**Our Case Number:** ABP-317679-23

**Re:** Ringsend to City Centre Core Bus Corridor Scheme.  
Ringsend to City Centre, Co. Dublin.

<p><b>Dublin Cycling Campaign</b></p> <p>The Tailors' Hall, Back Lane, Dublin, D08 X2A3. <a href="http://www.dublincycling.ie">www.dublincycling.ie</a> RCN 20102029</p>
<p>To: <b>An Bord Pleanála</b></p>	
<p>Date: 2023- October 3rd</p>	
<p>Re: <b><u>Ringsend to City Centre Core Bus Corridor (Case: 317679)</u></b></p>

TOM CLARKE BRIDGE

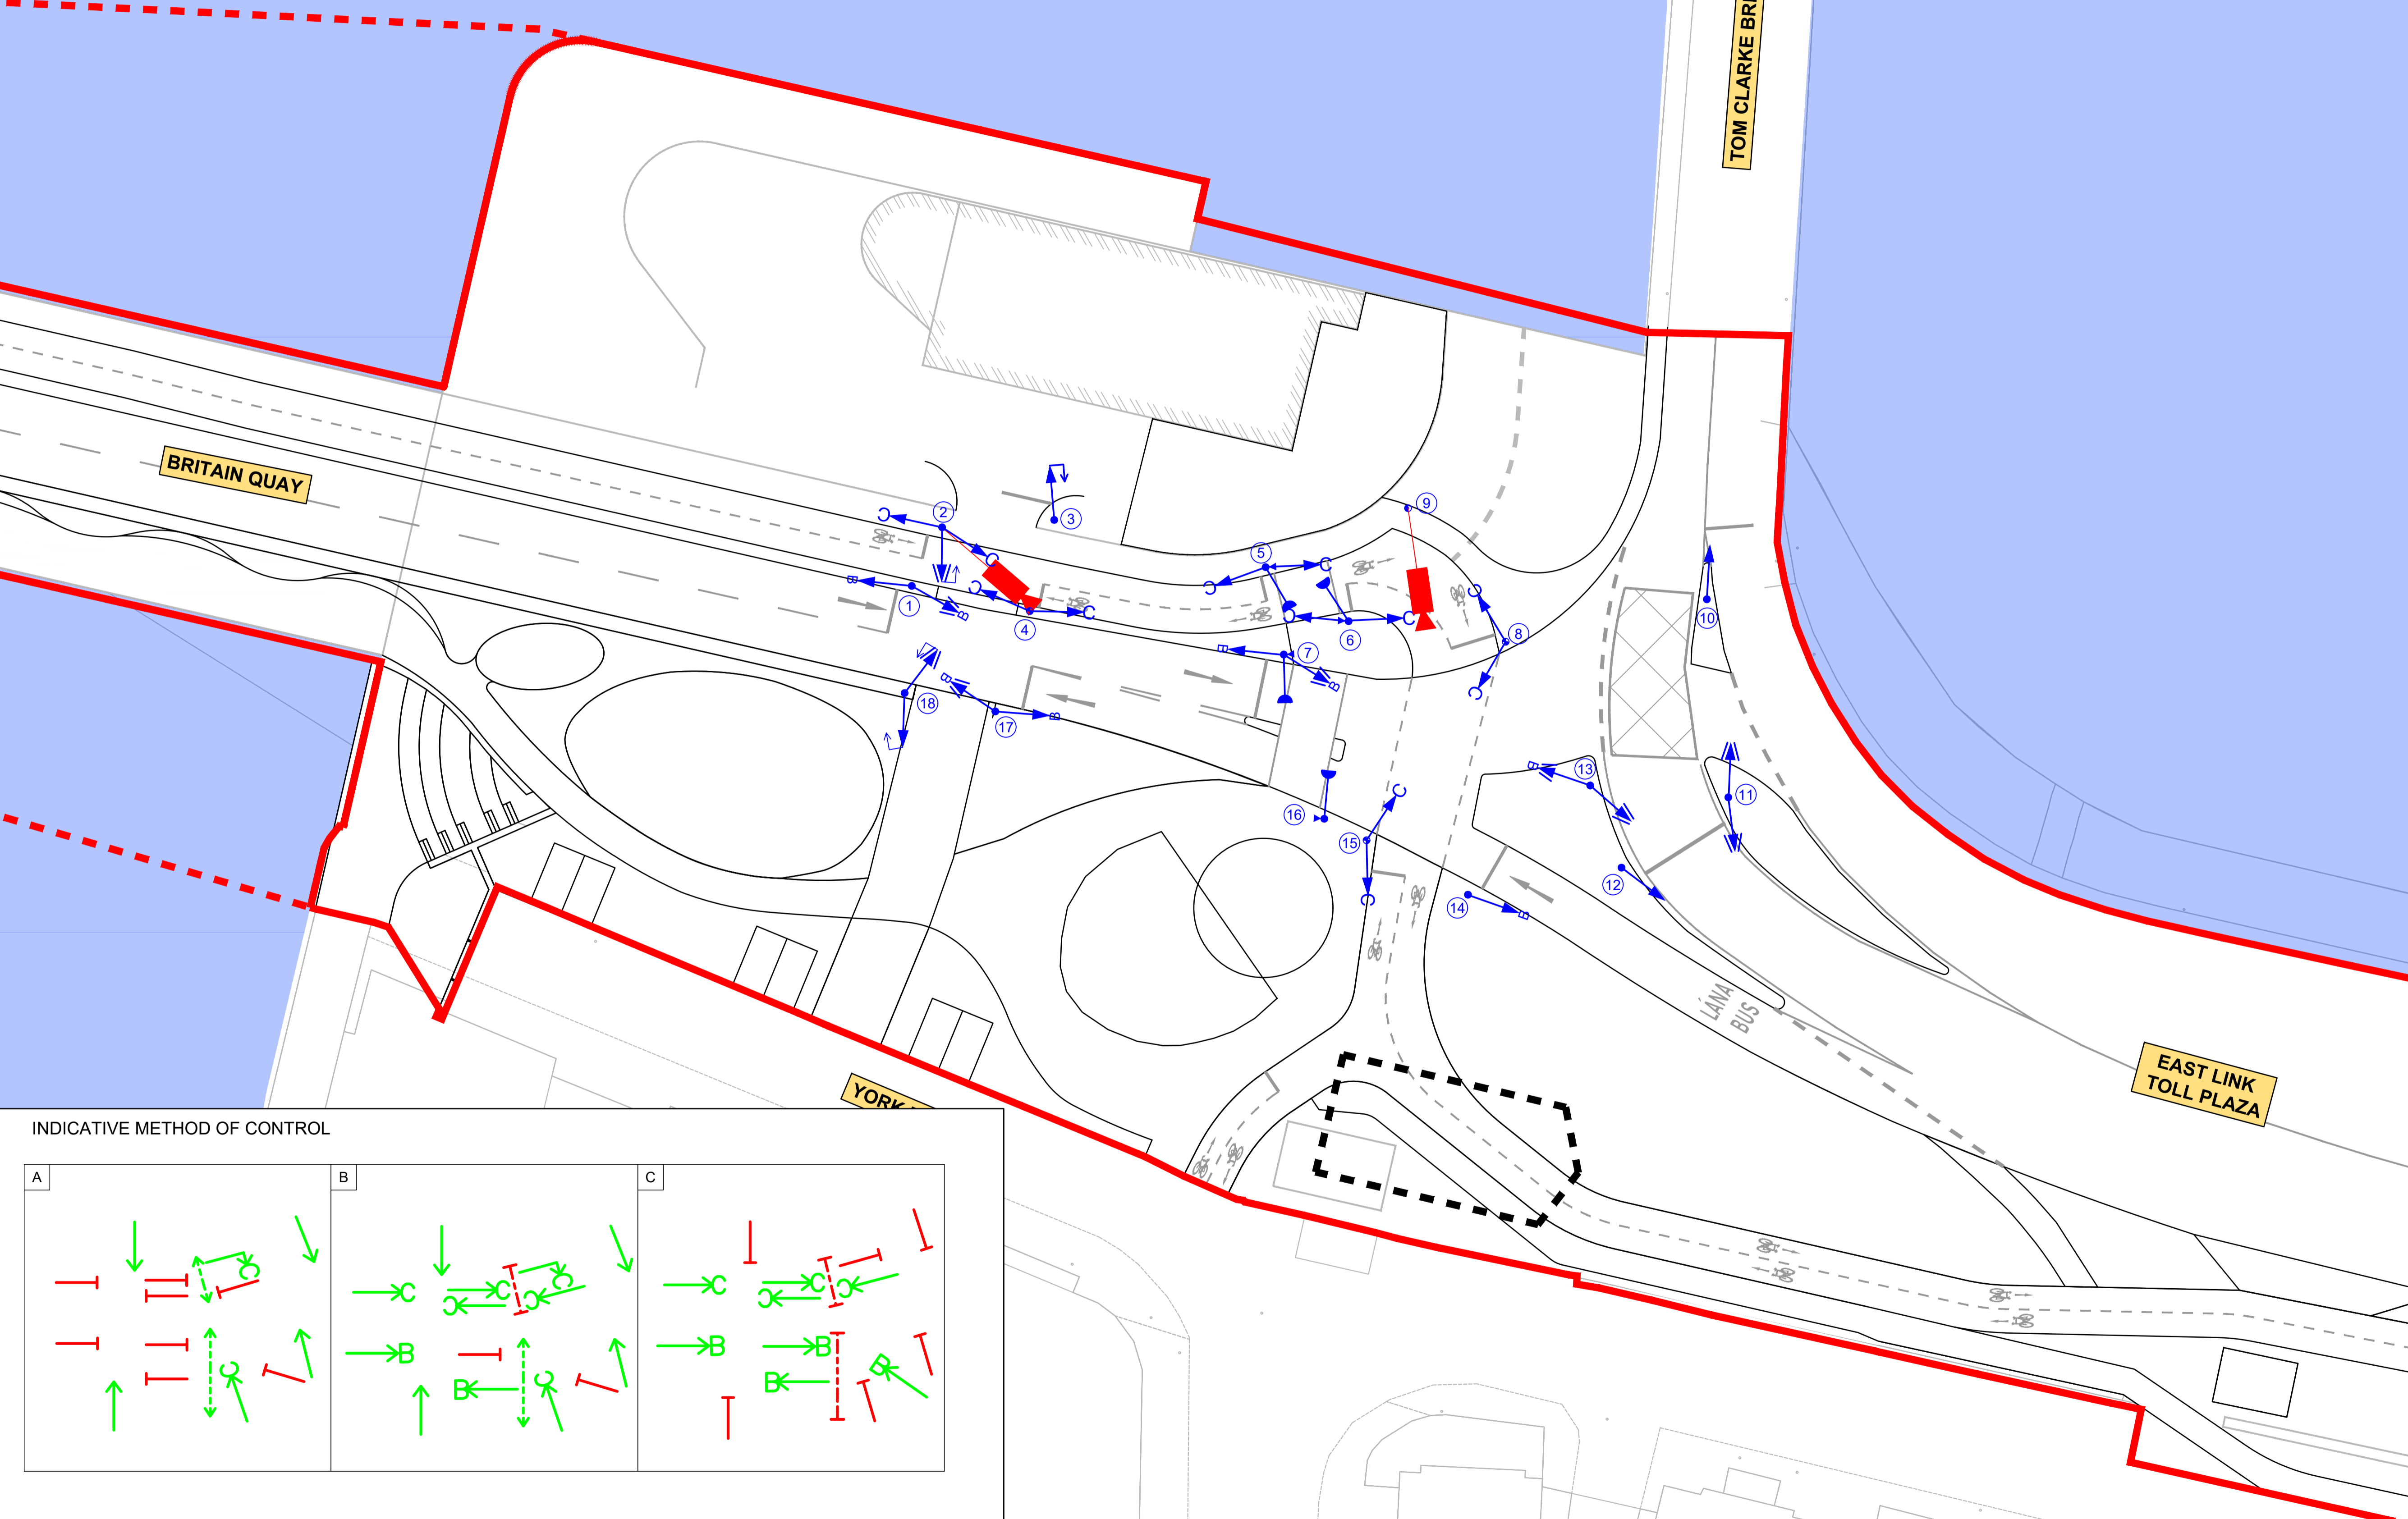
Sheet 05 - We note that designs for Tom Clarke bridge at the North Wall Quay do not align with the current proposals for that junction from Dublin City Council, which include the removal of the roundabout.

We submit that Tom Clarke bridge is extremely hostile to people on bikes, despite also being a critical link between the north and south of the city. Our members report that motorists frequently fail to follow cyclists patiently on the span itself, and frequently attempt unsafe overtaking. Footpaths along the span are of sub-standard width, making walking a bike across the bridge difficult if not unsafe.

We acknowledge the existence of the City Council Development Plan objective to provide a new parallel bridge, but in the interim we submit that, at the very least, signage to reduce motorists' speeds to 30km/h for the bridge span length, and to emphasise that overtaking of cyclists is unsafe on the span itself, should be part of the Applicant's designs. Ramps, speed tables, or other revised DMURS-compliant road designs that discourage speeding, might also usefully be considered.
